Application No: AW/129/22/HH
Site Address: 13 Gossamer Lane Aldwick PO21 3AT
Description of works: Single storey side/rear extension following the demolition of existing detached garage.

Thank you for your internet representation made on 17th June 2022 which has been recorded as an objection with the comments as follows:

DRAWING	SCALE
PLANNING PROPOSED	1/100
DATE: MARCH 2019	
DRAWN: T. Murray	
DRAWING: 19/15/3	REVISION:

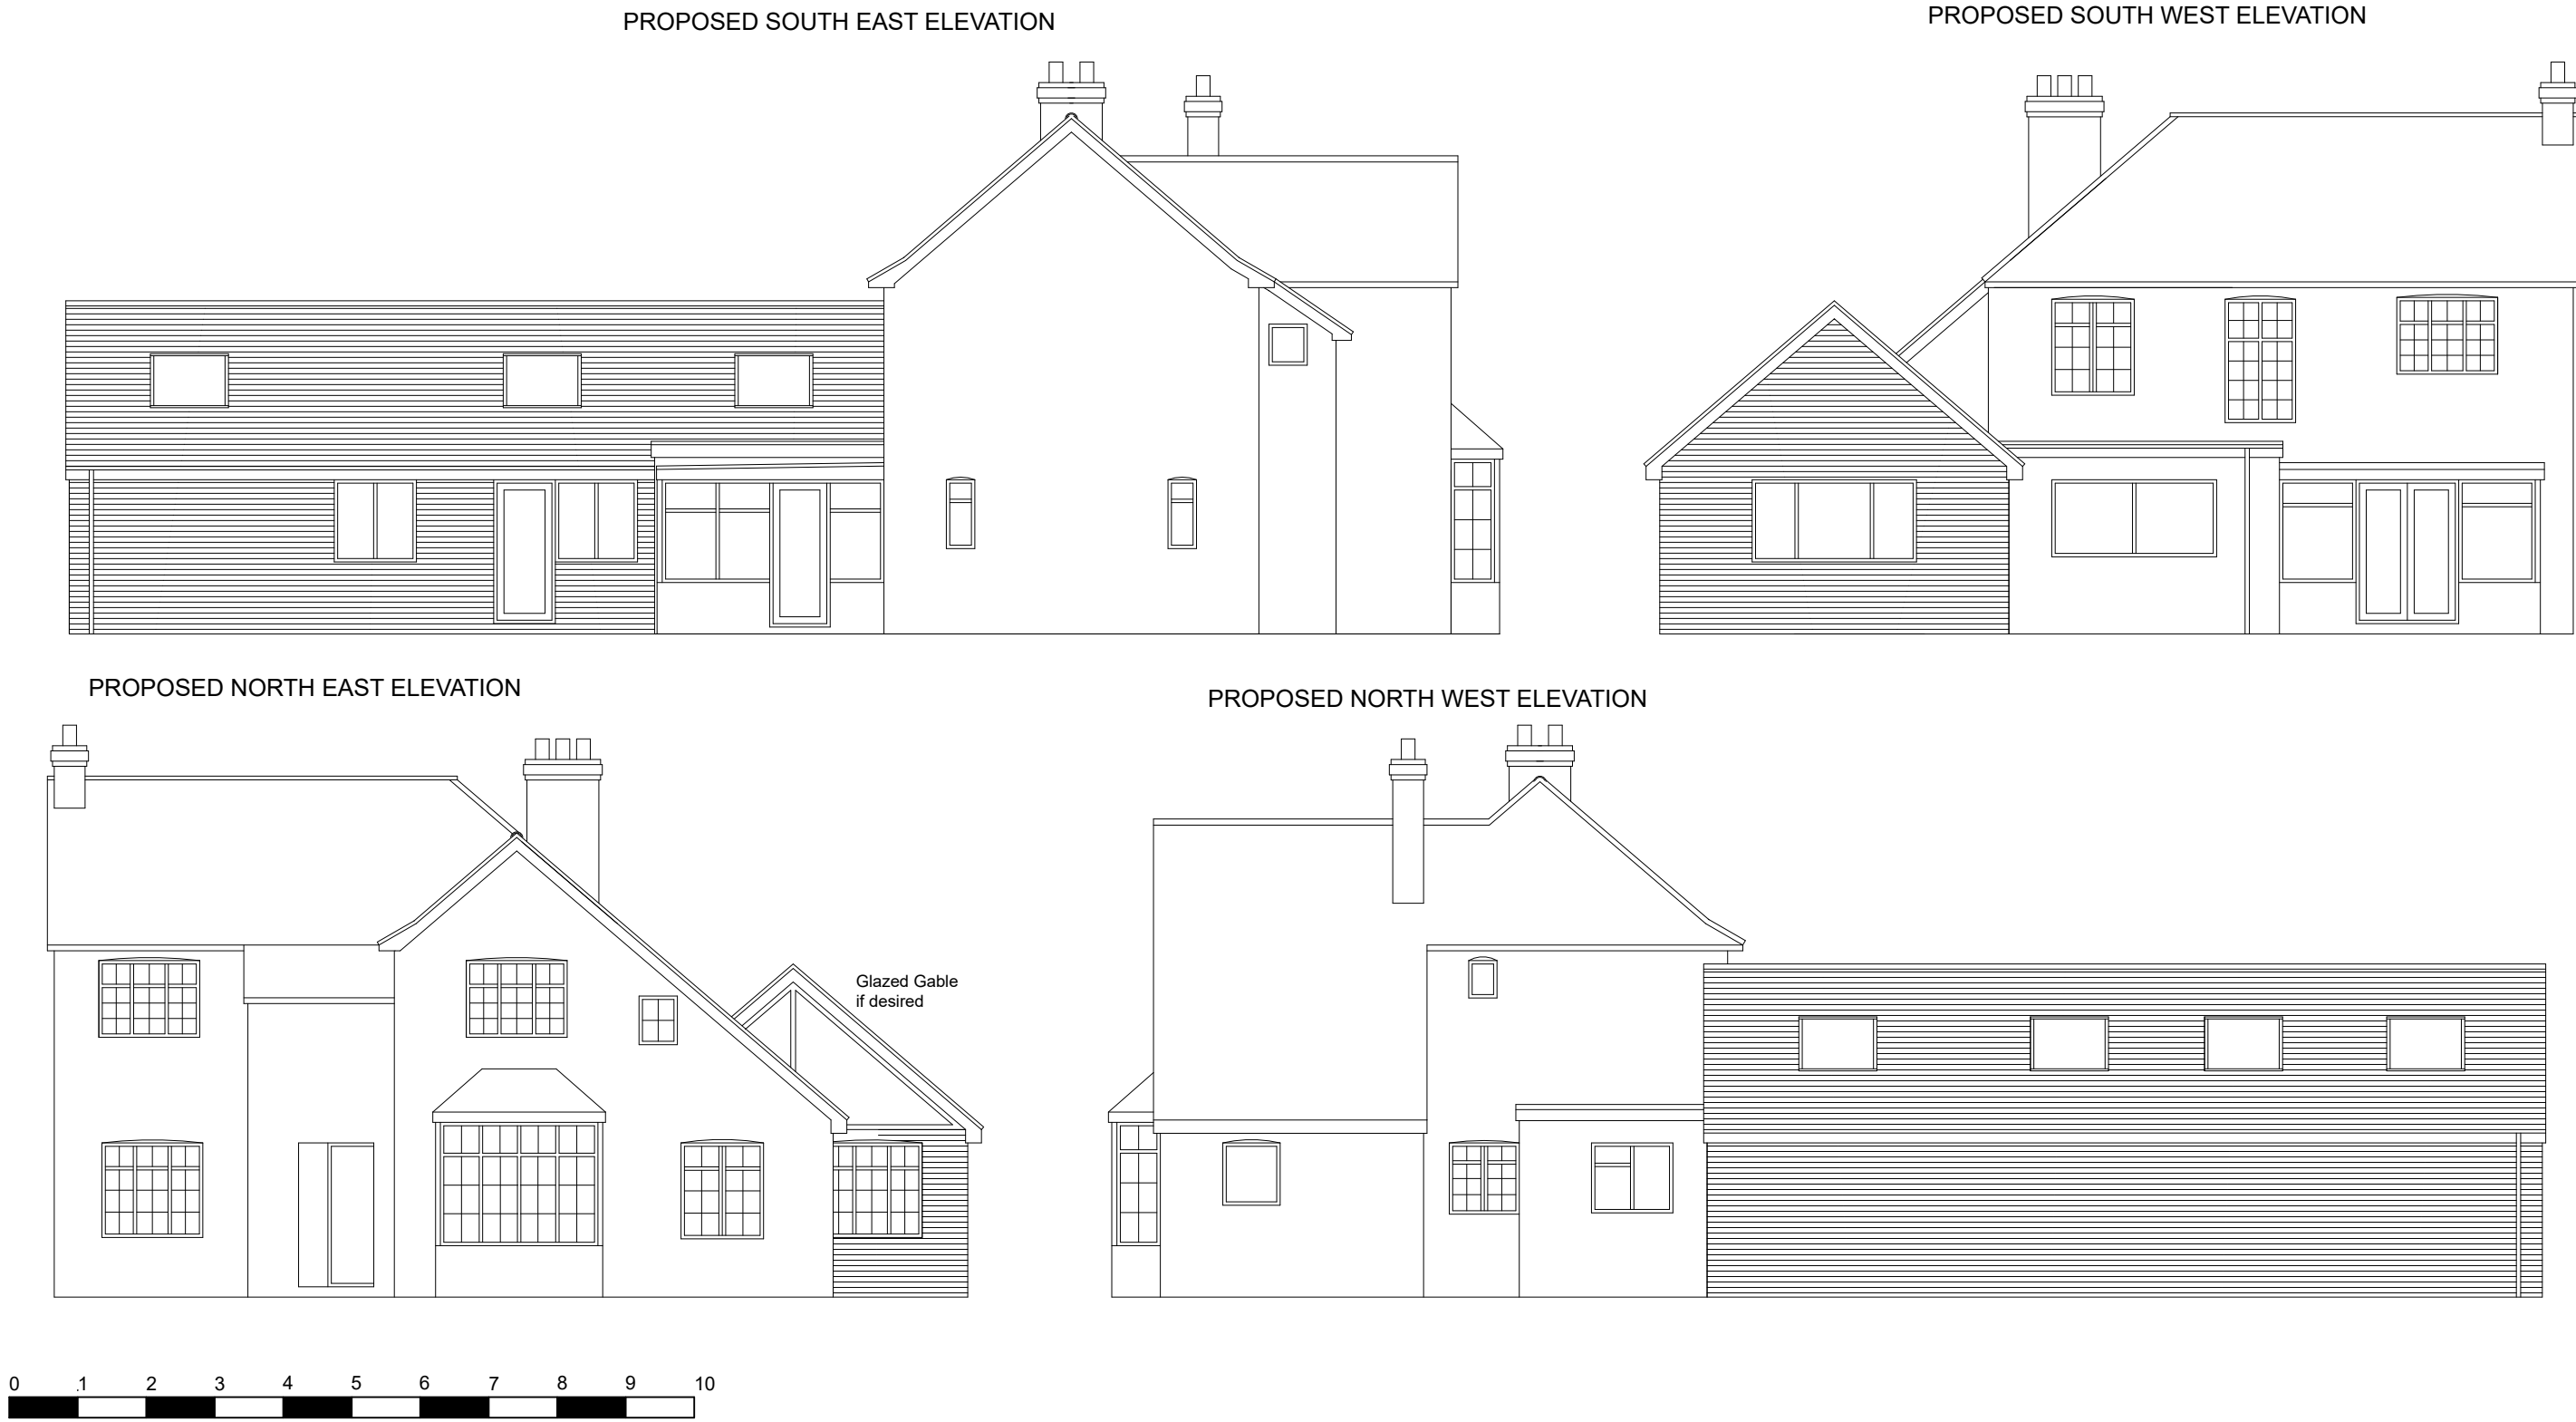
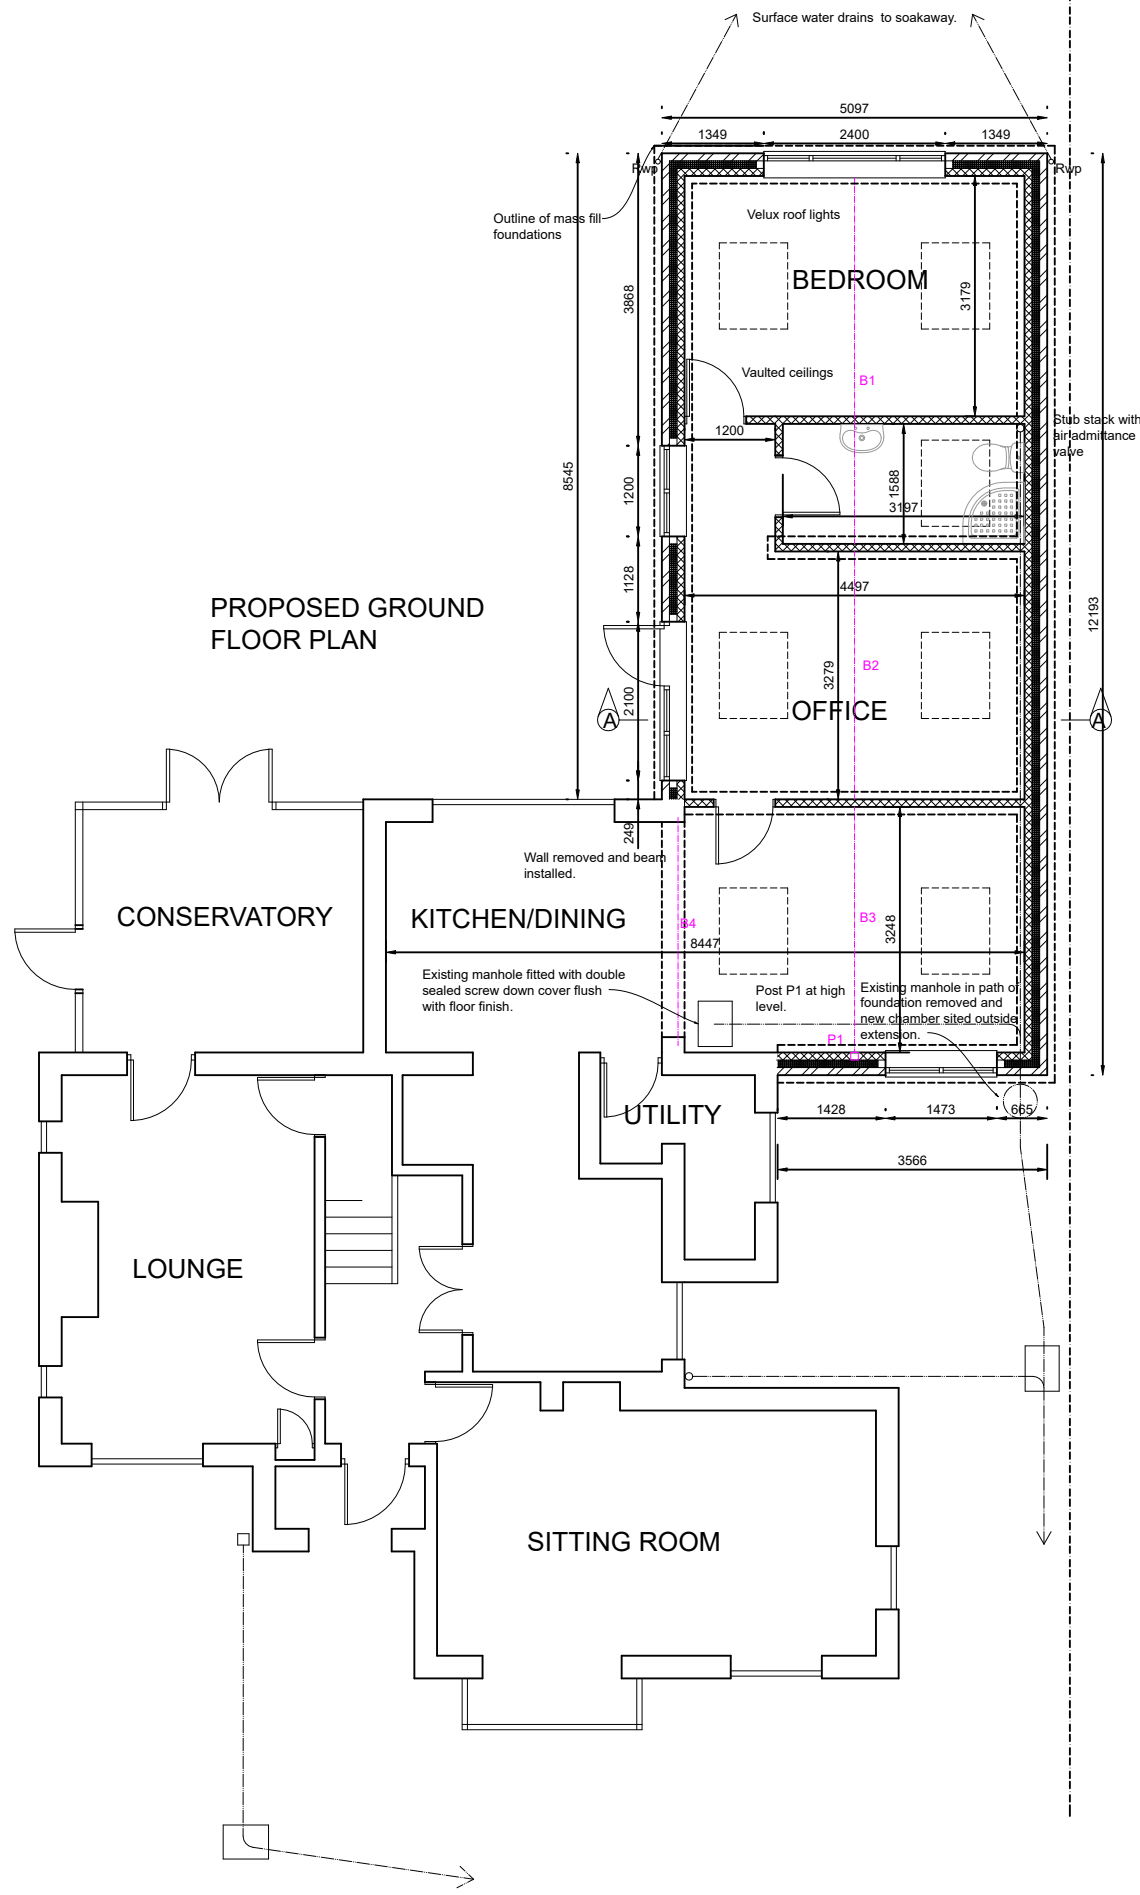
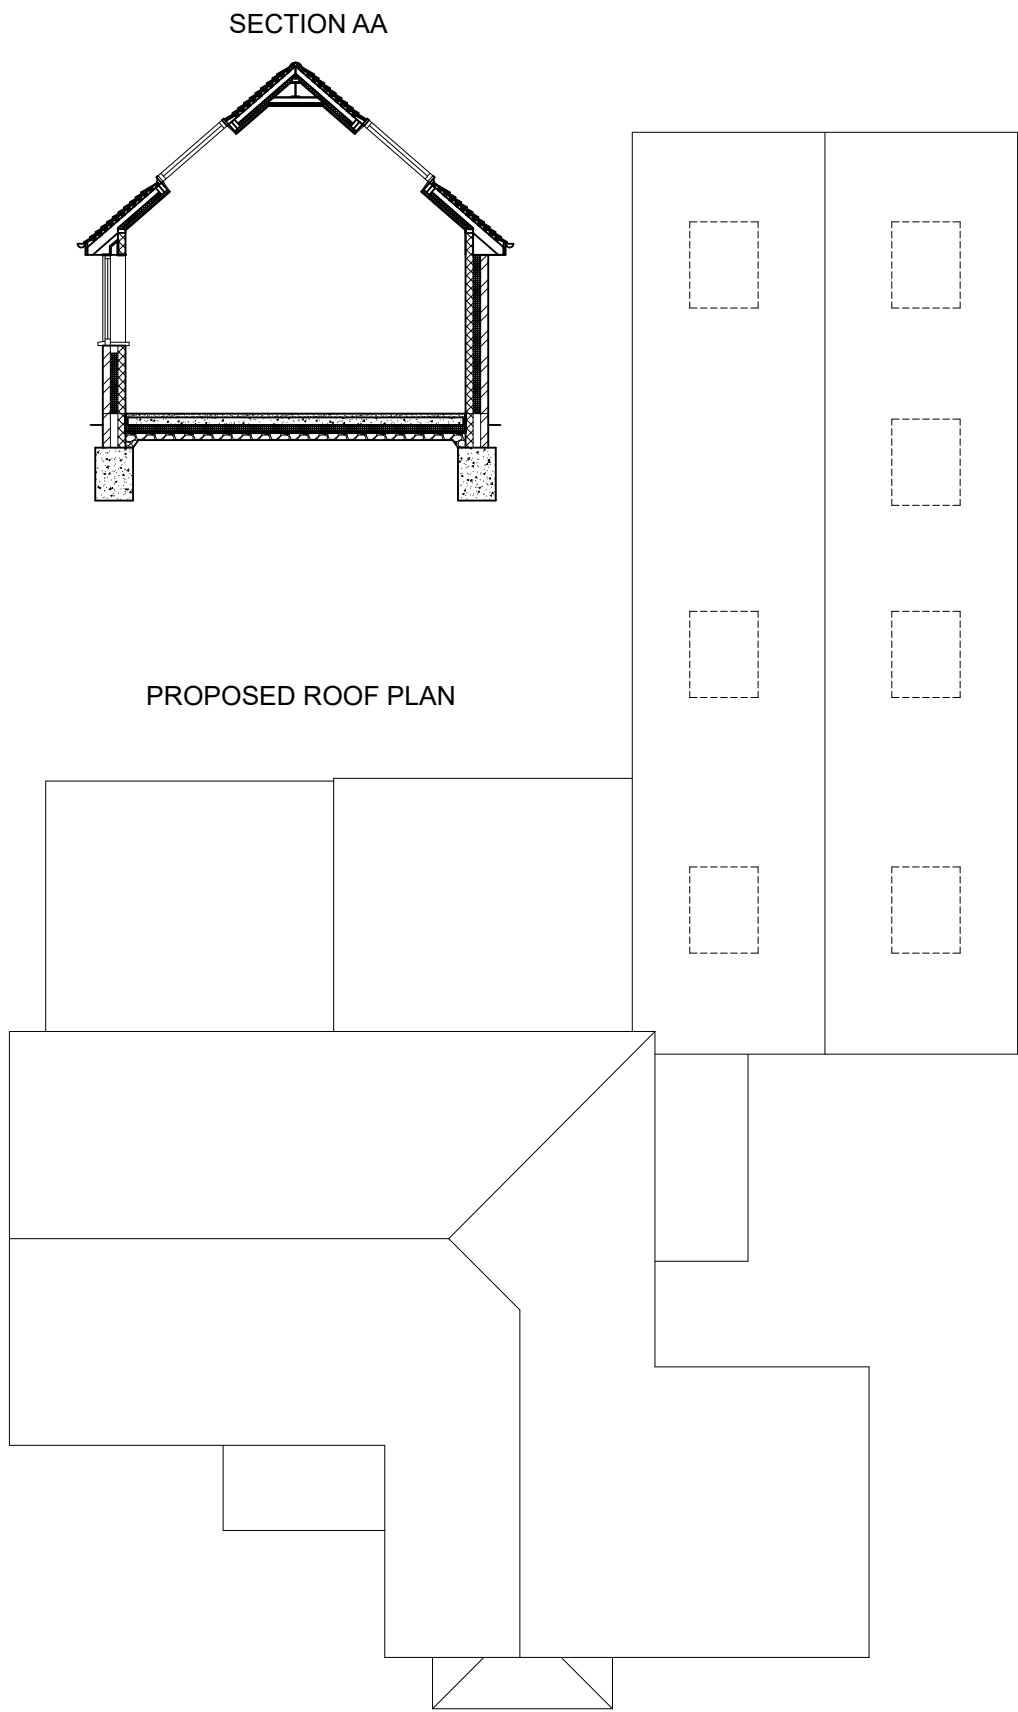
- 1) The roof of the current garage can clearly be seen from one of my back bedroom windows, and this is approximately where one of the proposed new roof windows would be sited. I worry that this would cause a mutual loss of privacy especially if it were to be an opening window. As this roof window is only one of seven and I believe that removing it from the plan would not significantly compromise the overall design.

- 2) The block plan (549a1bdc61394c3.pdf) shows a figure of 03 for the clearance from the boundary and it is not clear if these means 0.3 (i.e 30 cm) as the decimal point is obscured. I'd like this to be made clear to allay my concern that there isn't enough clearance for guttering where it would come close to my own walls.
